March 16, 2022

RE: Proposed Minor Amendments – Walmart Neighborhood Market – 1820 Unser Blvd. NW

I reviewed the submittal for the proposed amendments to the approved, most recent site plan for the Walmart Neighborhood market site. Some items were not provided and others need elaboration, as noted below:

**SSM-1**

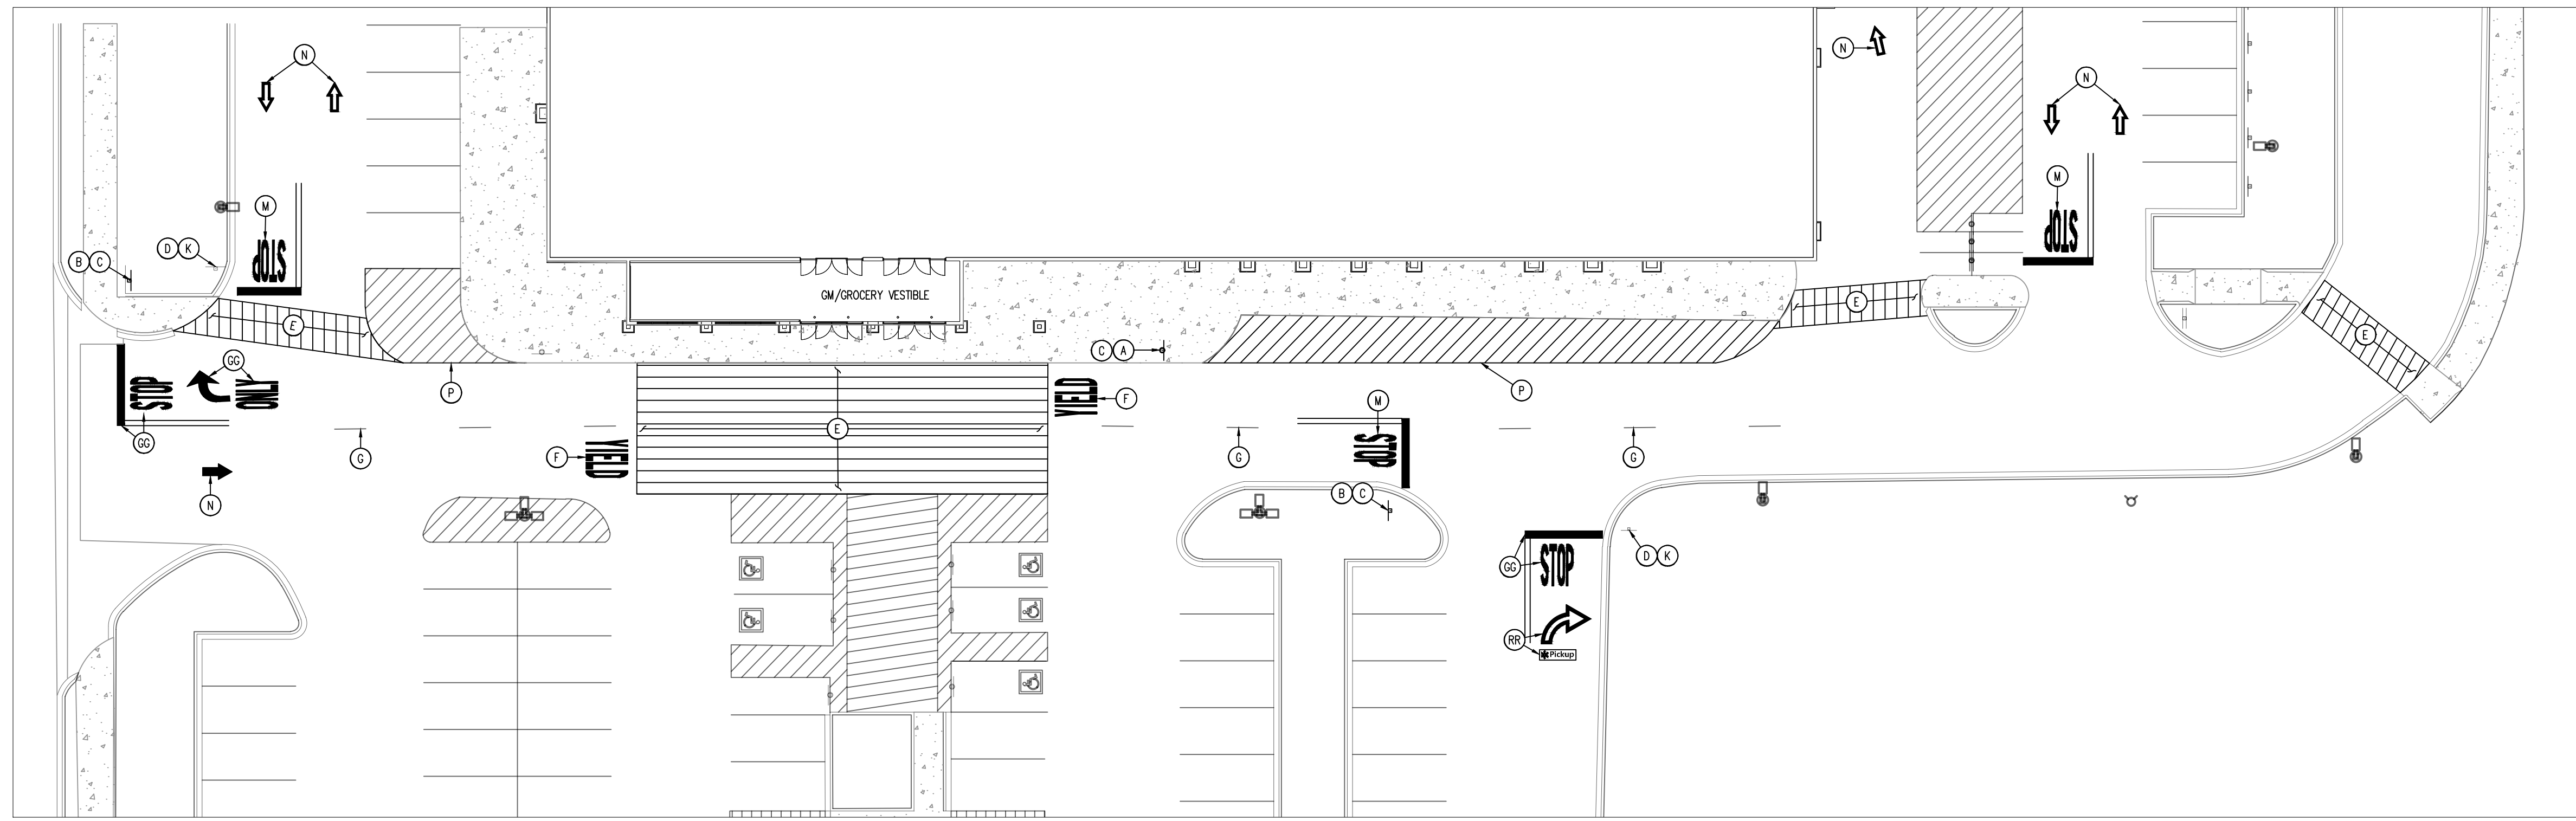
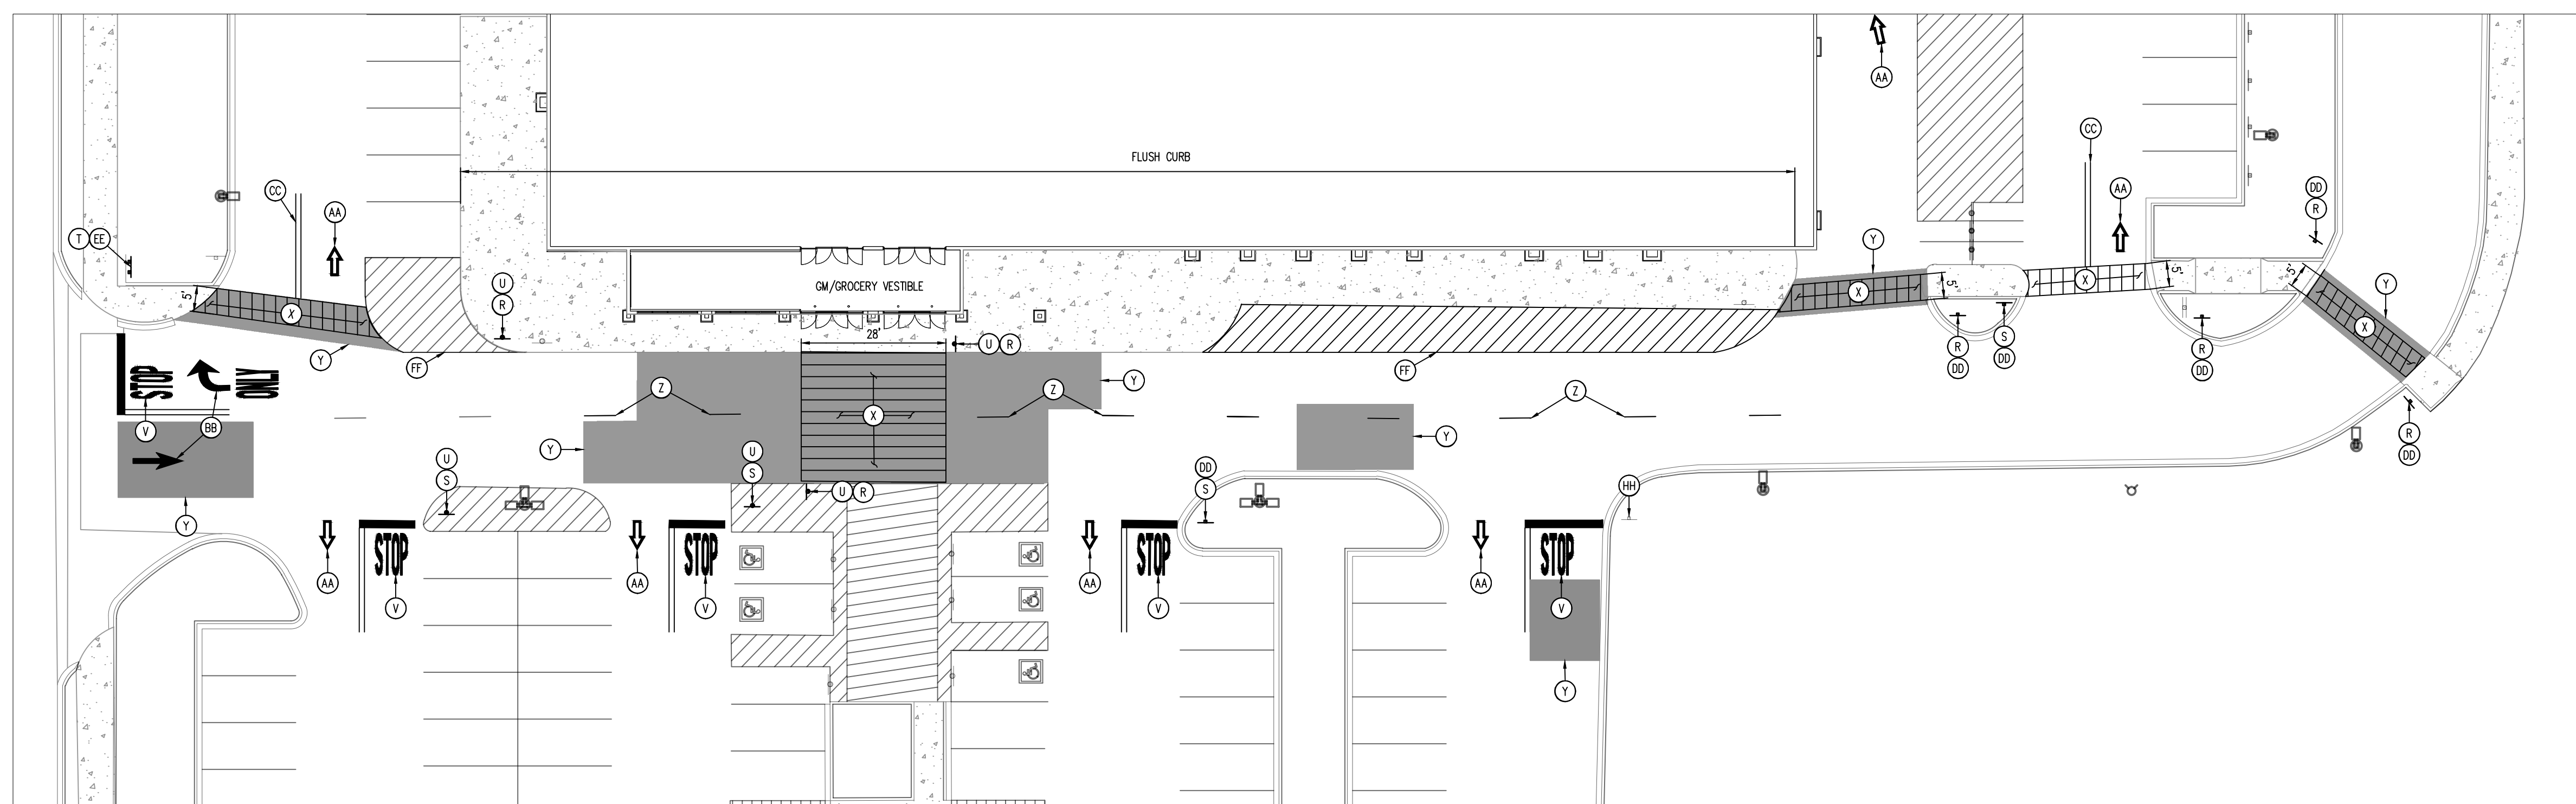
6. I’m having a difficult time navigating the site plan sheets submitted, which appear to have been excerpted from another site plan. For the AA submittal, we do not need construction drawings. Rather, we are evaluating the relationship between what’s proposed with this AA to what is approved and exists.
7. That said, I see the approval stamp from August 2021, but it’s on a separate sheet of paper and not on the site plan sheets. Please provide:
  - A. One electronic copy of the most recent, approved site plan (all sheets) that pertains to the August 2021 stamp (usually the stamp is on the drawings). Clean copy- no marks.
  - B. One updated electronic copy of the August 2021 approved site plan with bubbling to indicate the proposed changes and keyed notes (1, 2, 3, etc.) to explain them.
